From: Eve Hearsey
Sent: 03 August 2010 12:26
To: Nicola Spencer; Lisa Coney
Subject: FW: East Beach Cafe - LU/189/10 - Copy of our comments

From: Graham Evans
Sent: 22 July 2010 16:13
To: Planning.Responses
Subject: LU/189/10

LIGHTING AT
EAST BEACH CAFE
THE PROMENADE
SEA ROAD,
LITTLEHAMPTON, BN17 5GB.

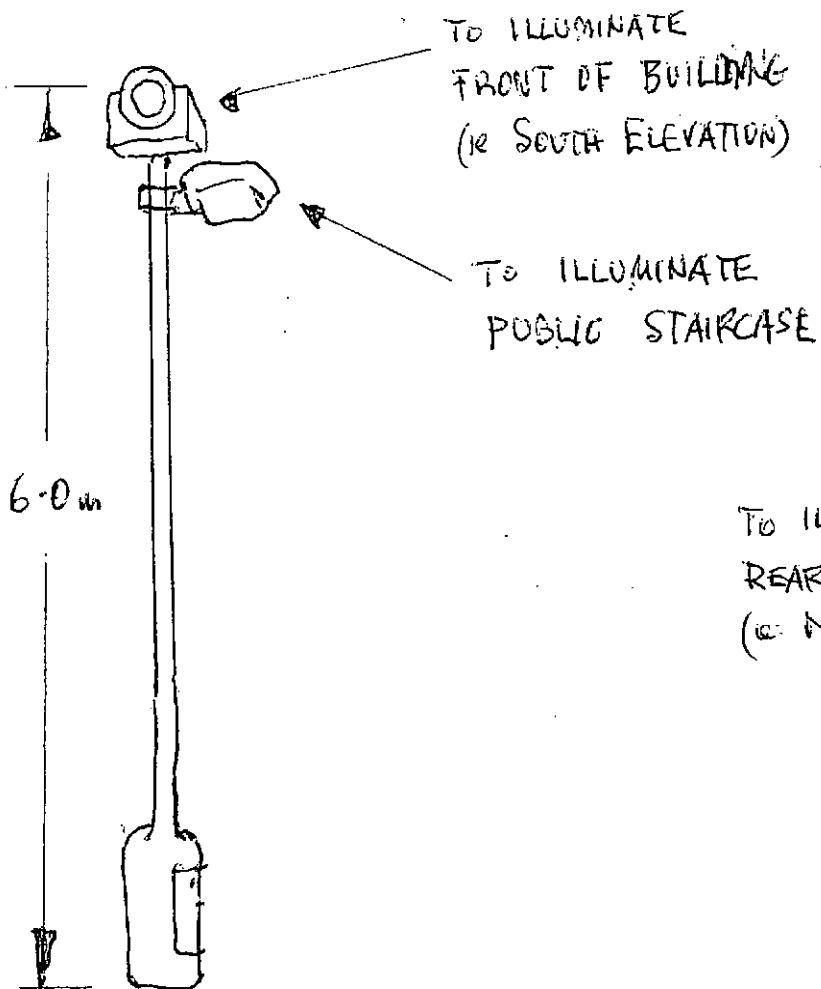
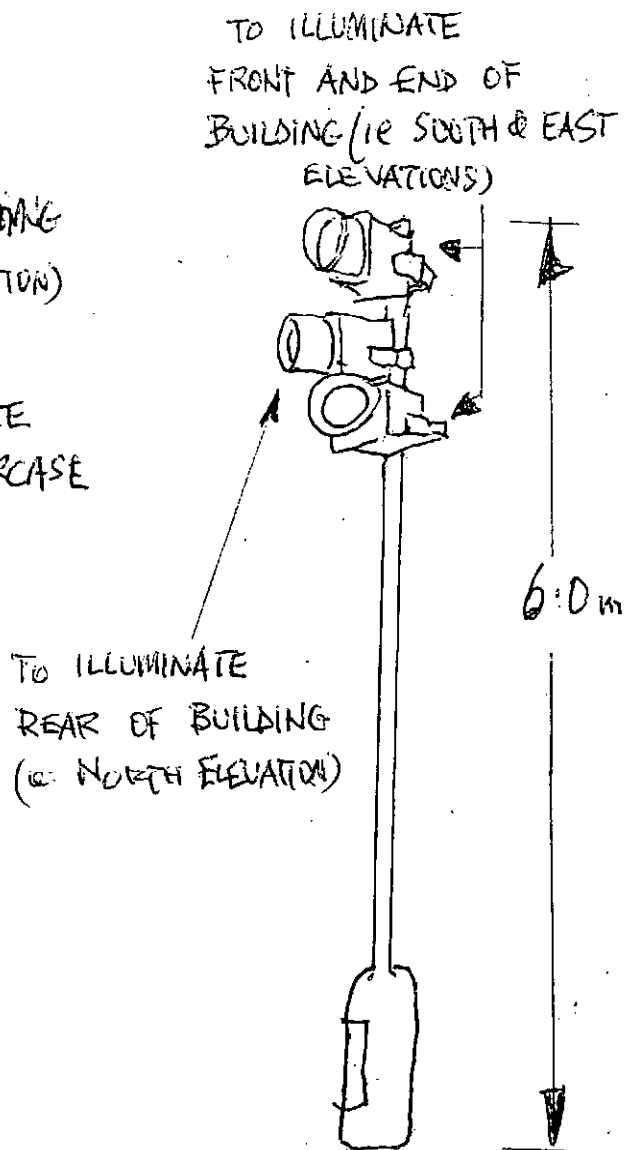
This Department has received complaints from members of the public concerned that lighting at this premises shines horizontally along the promenade into the eyes of pedestrians. This has not been addressed in the application and I would draw the applicants attention to the attached ILE Guidance.

In particular, glare should be kept to a minimum by ensuring that the main beam angle of all lights directed towards any potential observer is maximum 70 degrees (from the vertical). Also that lighting equipment should be specifically designed to minimise the upward spread of light near to and above the horizontal.

The applicant is requested to consult a professional lighting designer and provides appropriate details to demonstrate that the proposed exterior lighting installation meets the obtrusive light limitations recommended for Environmental Zone E2.
